Health Research Facility, Alexandria (SSD-63067458)

Submission in response to public exhibition of the EIS

EME Advisory (EME) has been engaged by the owner of a residential property at 102 Wyndham Street, Alexandria to review the EIS for a proposed Health Research Facility (the project) on the neighbouring site at 100 Wyndham Street (the project site). 102 Wyndham Street is located immediately adjacent to the southern boundary of the project site.

Figure 3. Proposed Basement Excavation and Proximity of 102 Wyndam Street

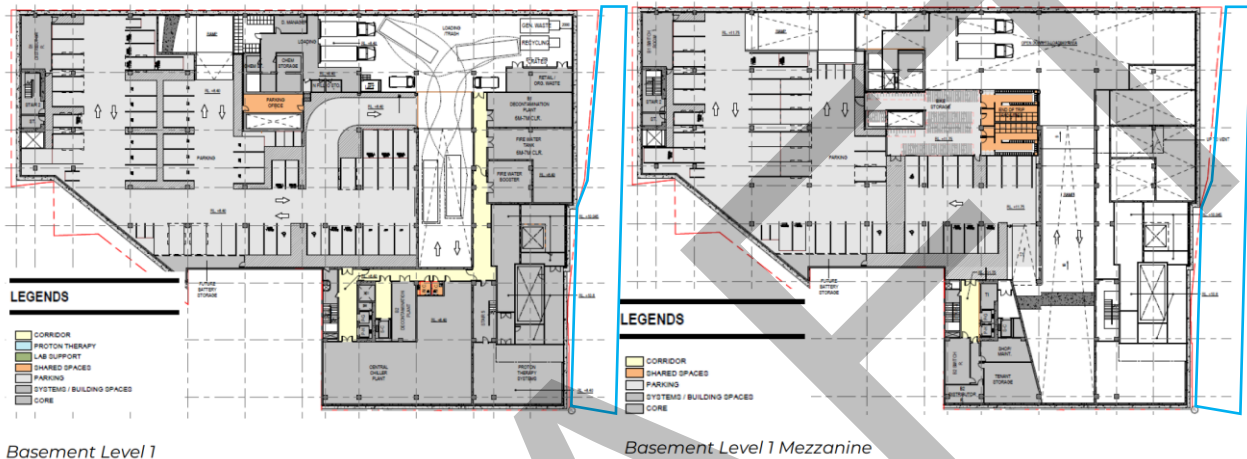
Another point identified in the review is the absence of a vibration assessment. Information presented in the EIS indicates excavation of the basement levels will be within 1-2 m of the 102 Wyndham Street building façade. At this proximity, there is a real risk of exceedance of human comfort vibration criteria and potentially structural damage criteria depending on the final construction method. However, this has not been assessed.
